File No. D07-12-17-0162

**Subject: Technical Circulation Comments
Site Plan Control Application: 3058 Jockvale Road**

The following comments are provided in response to the submission received by the City on May 4, 2018 and deemed complete on December 19, 2017:

C2

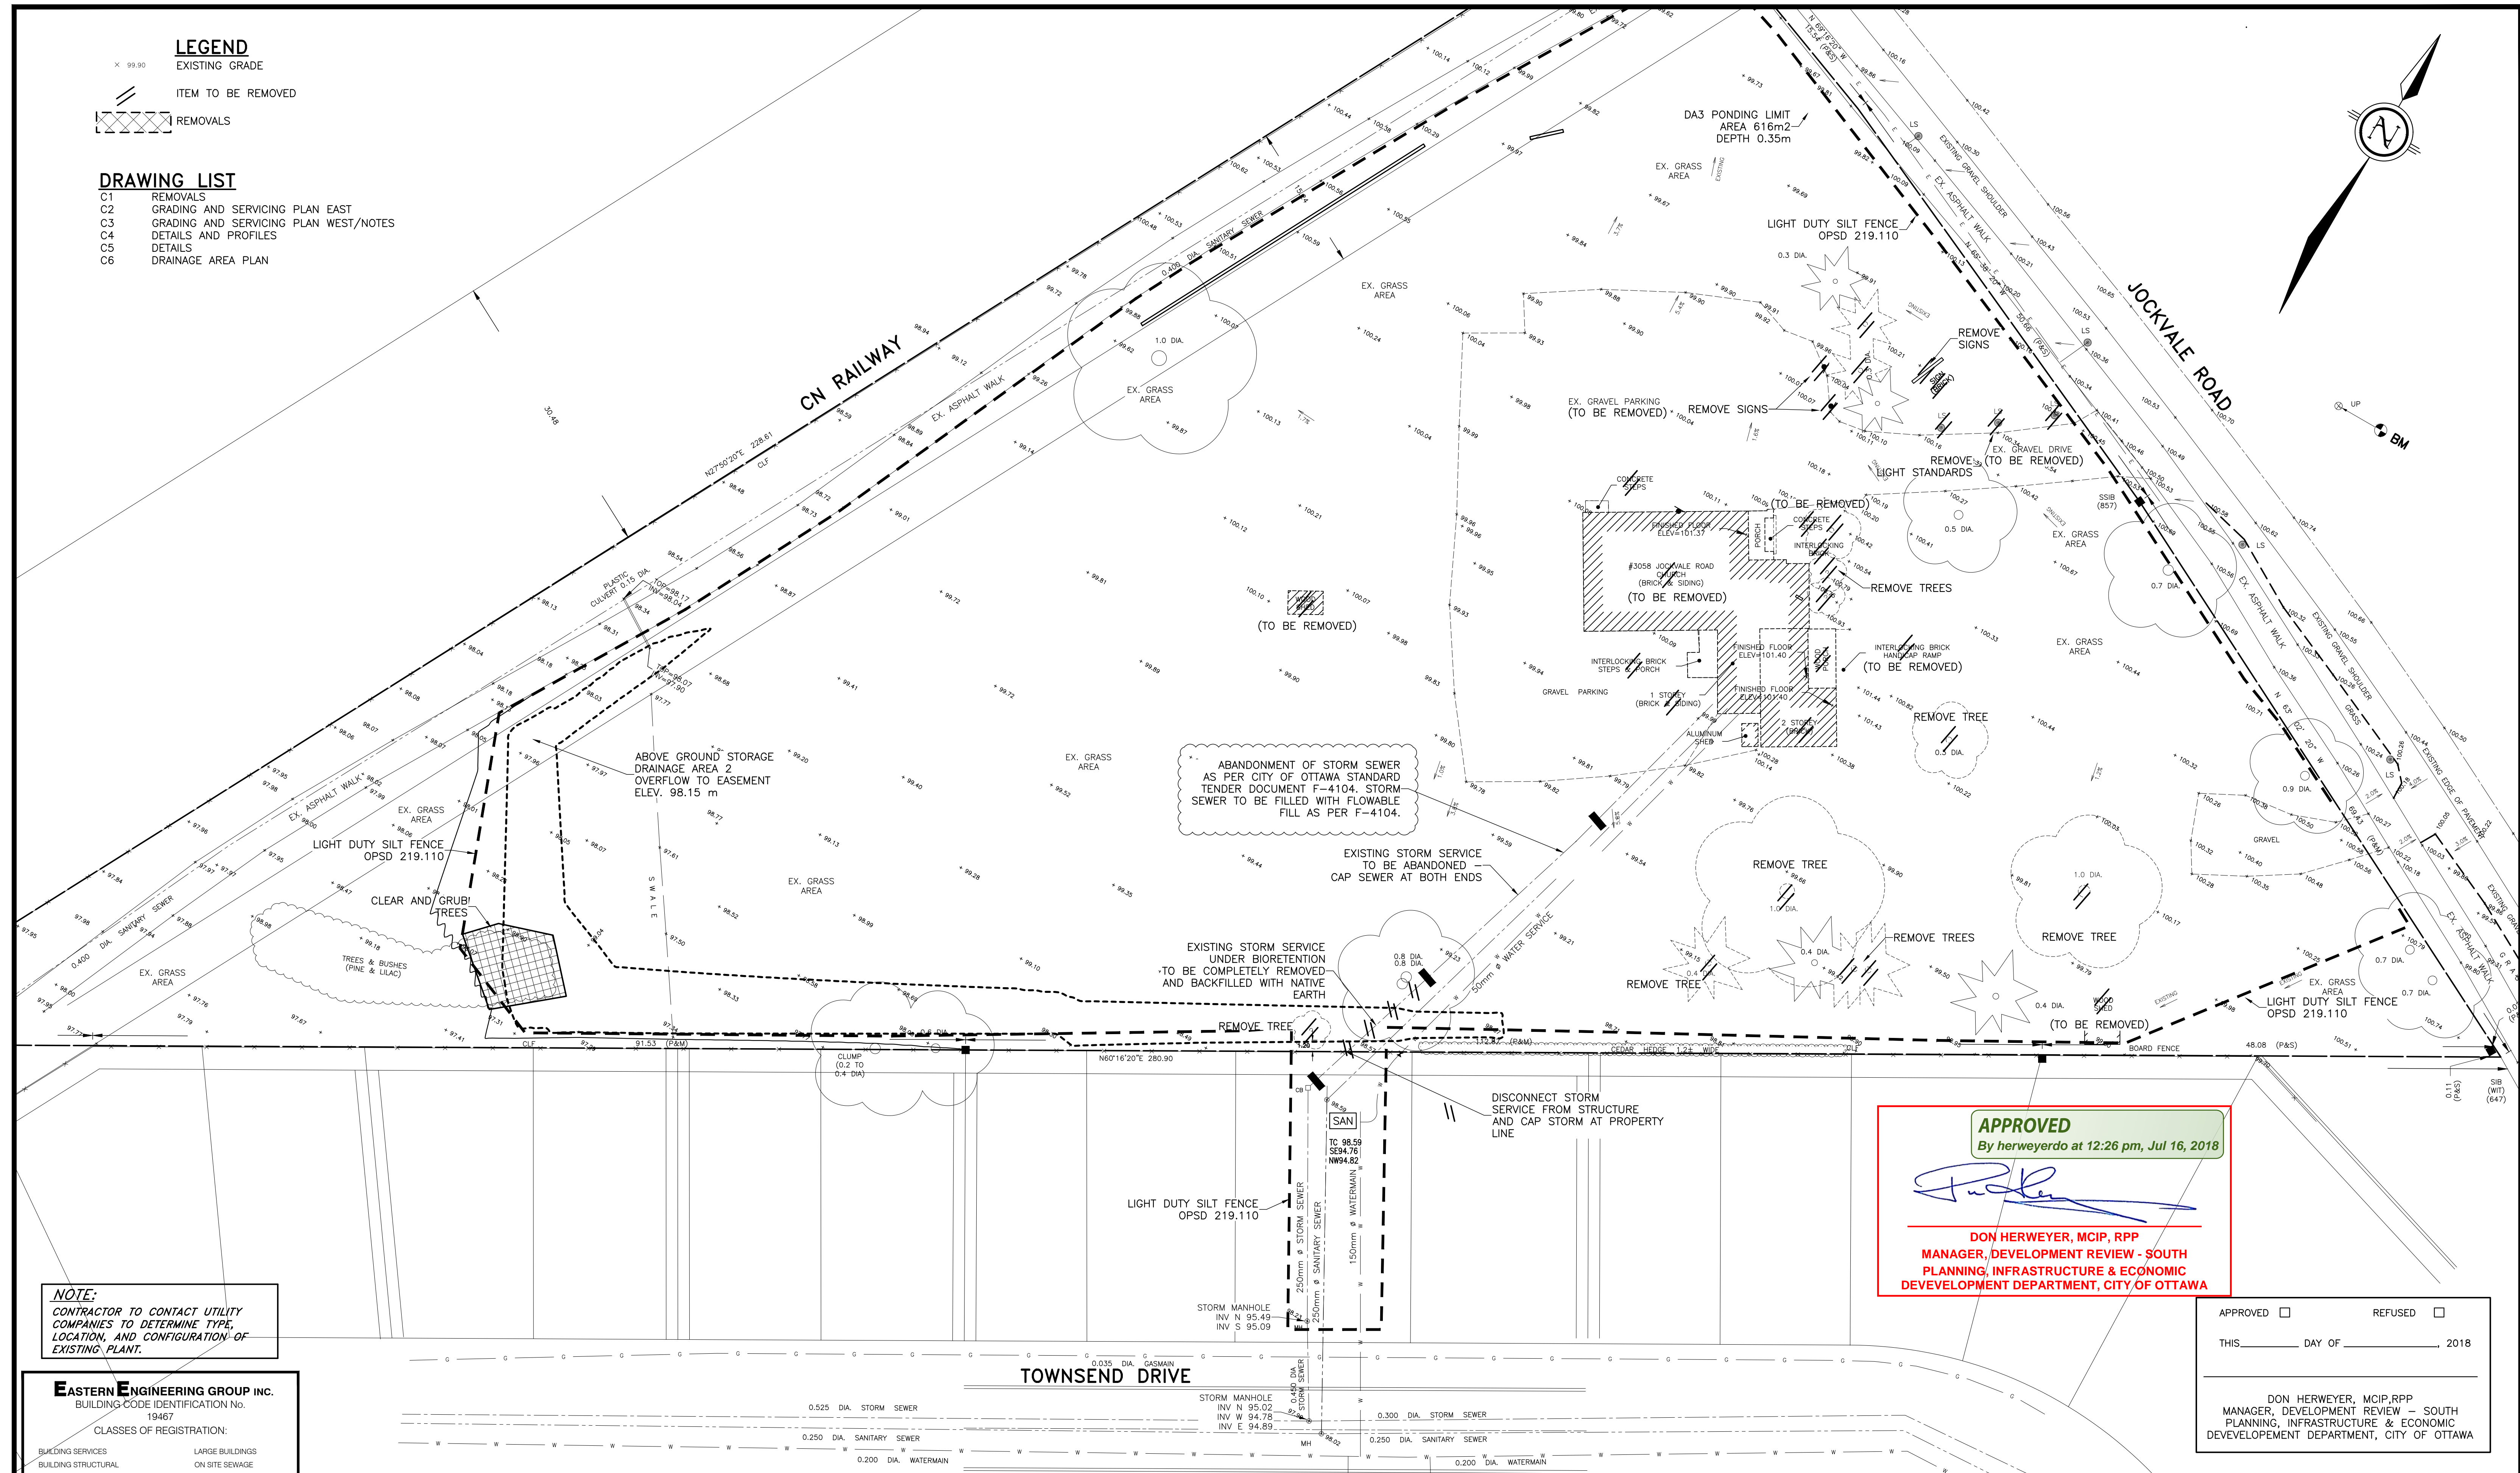
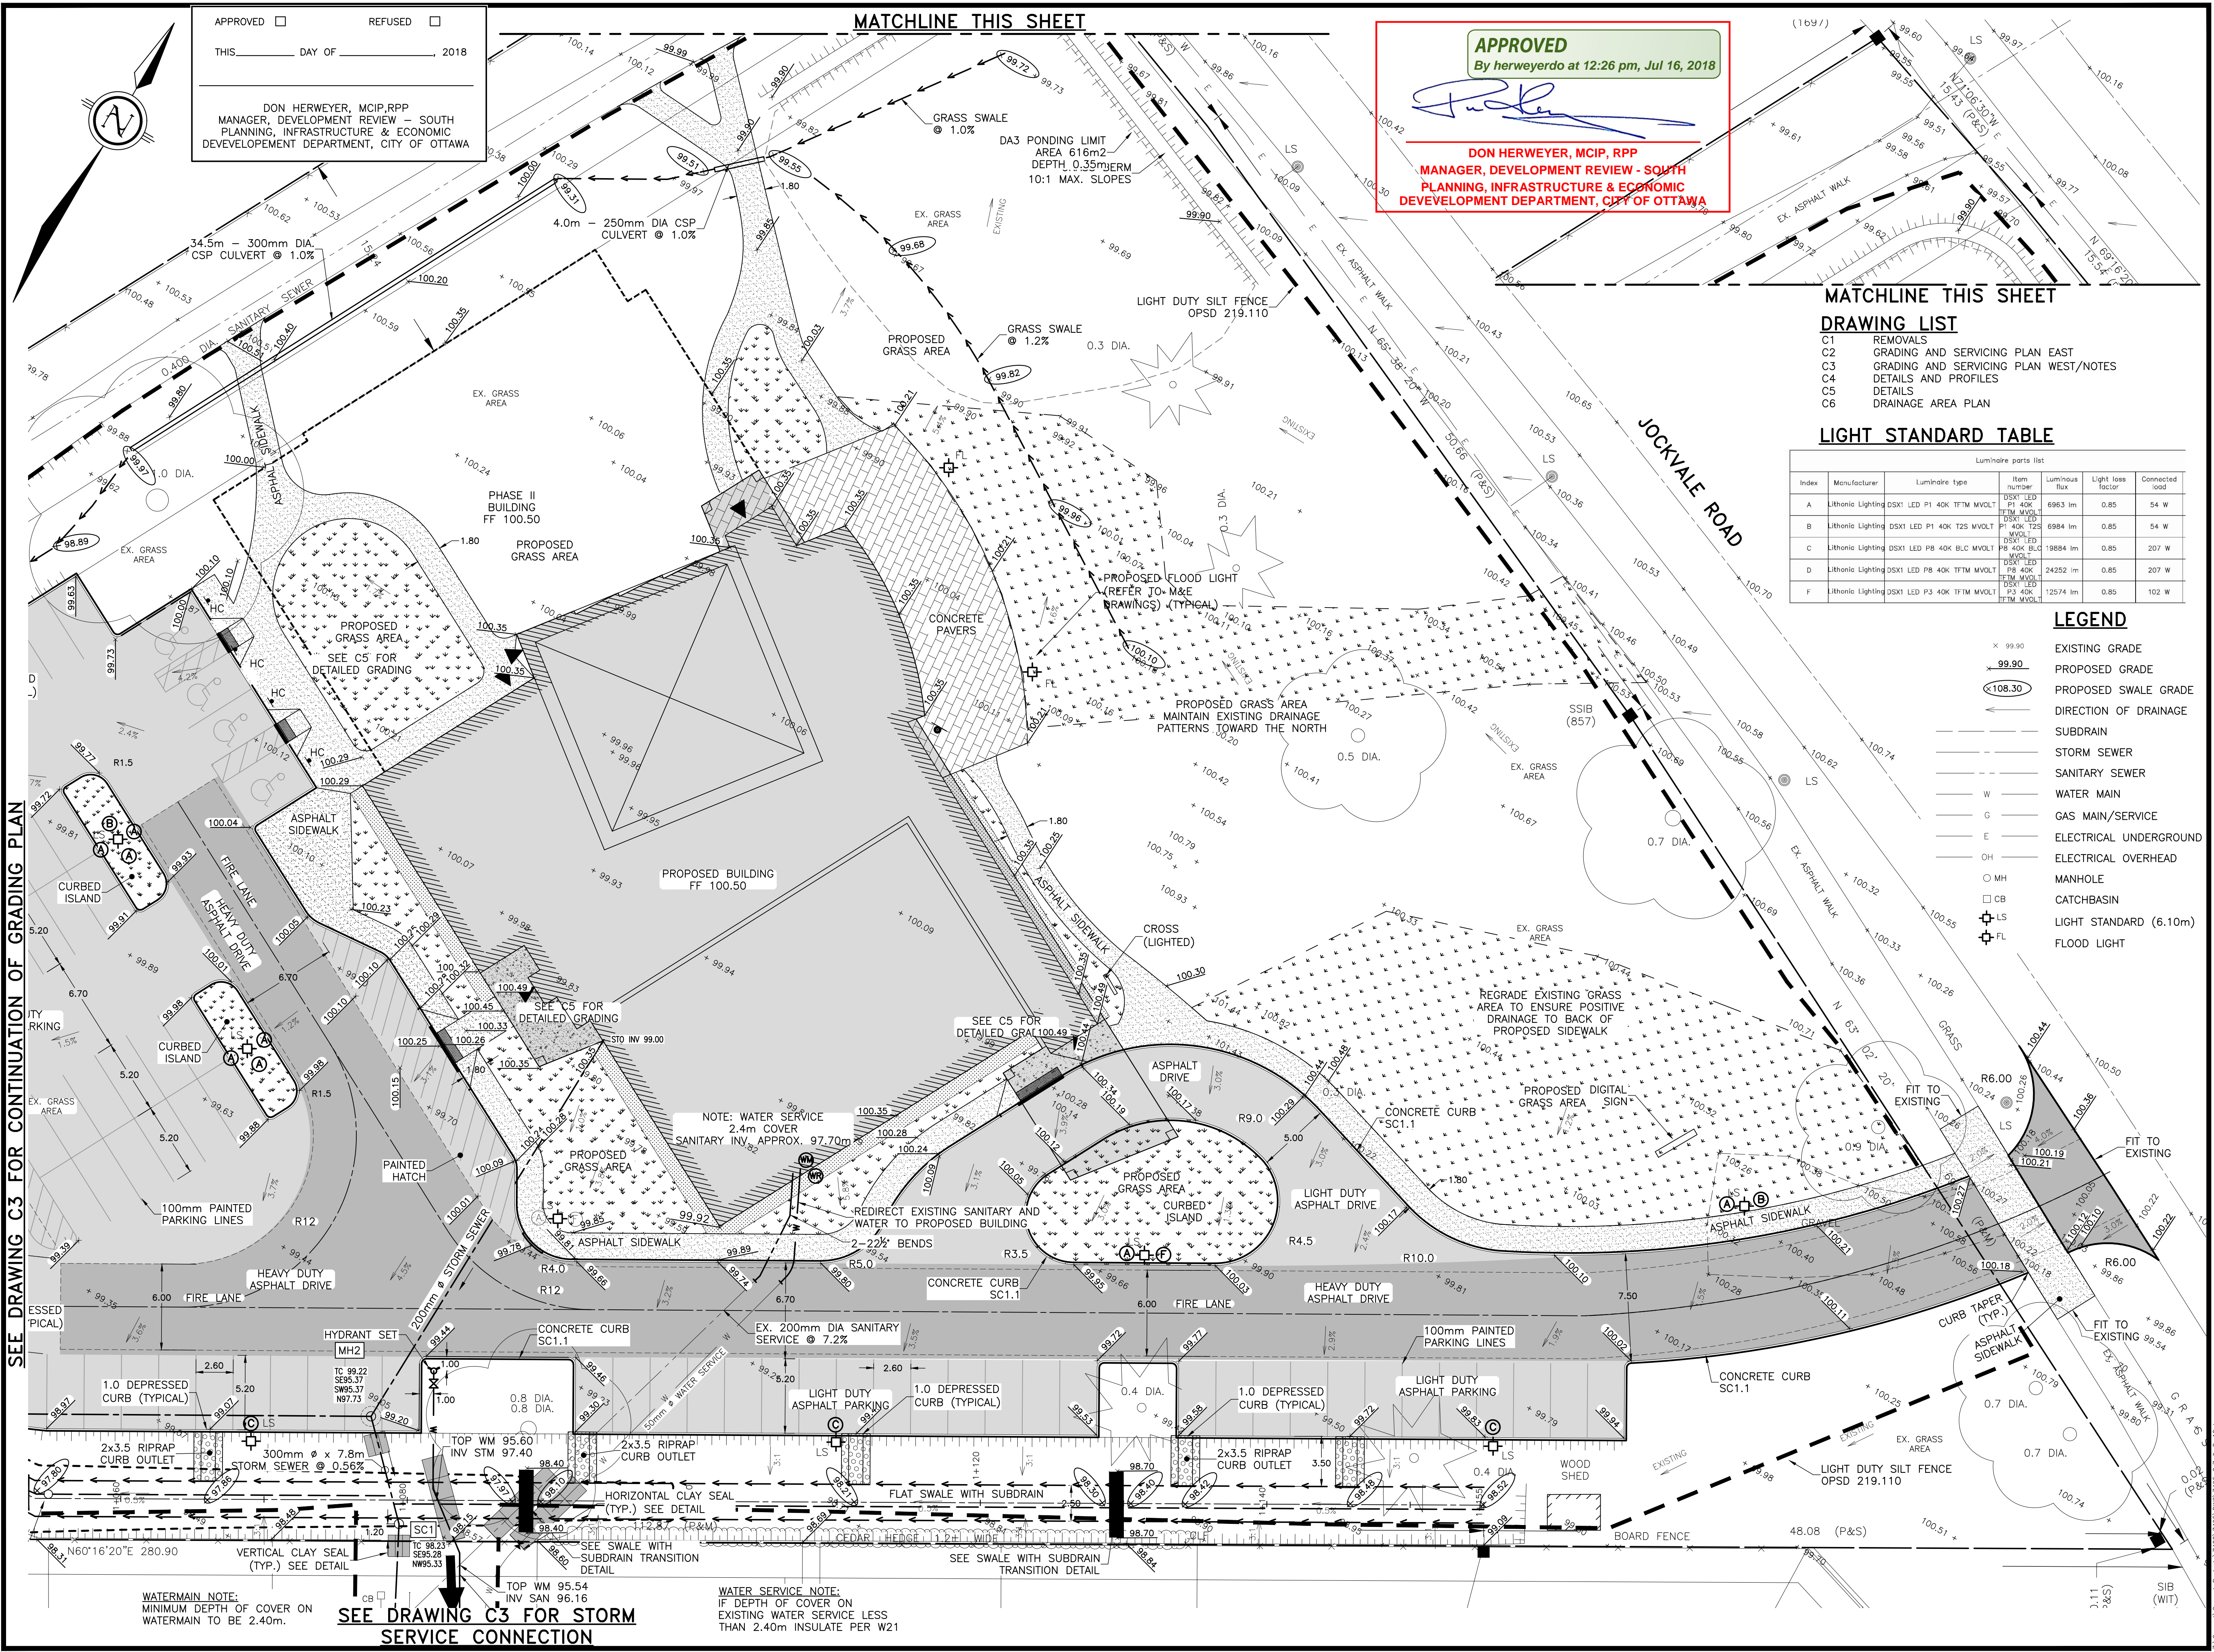
7. Redirect the lowest grade of the proposed swale towards the easement to direct the emergency overland flow towards the City right of way through the easement. **The swale grades still drain overland towards the storm retention area. The overflow will be at the grade 98.20 only when the site has reached overflow status during greater than 1:100 year storm event. We have removed a grade arrow that showed 3:1 from this area. The east/west swale cannot be redirected through the easement as the stormwater needs to be controlled on site.**

8. Provide the head of the ICD on the plans. **The head on the outlet control structure, SC1 is now shown on the structure table on C3, in Note 1. The head is 2.92 m.**

9. Plan C3 shows existing 250 mm storm and proposed 300 mm storm sewer both connecting to the existing manhole at the same location. Revise and update **The new connection is at an invert of 95.14m with the top of the 250mm pipe at 95.39. The existing pipe invert to the north is at elevation of 95.49 m. The new pipe will be cored into the existing manhole below the existing pipe. The outlet invert in the storm manhole is 95.09 m so there is a small area for adjustment if needed. There is no adjustment necessary to the drawings. Shop drawing review will confirm.**
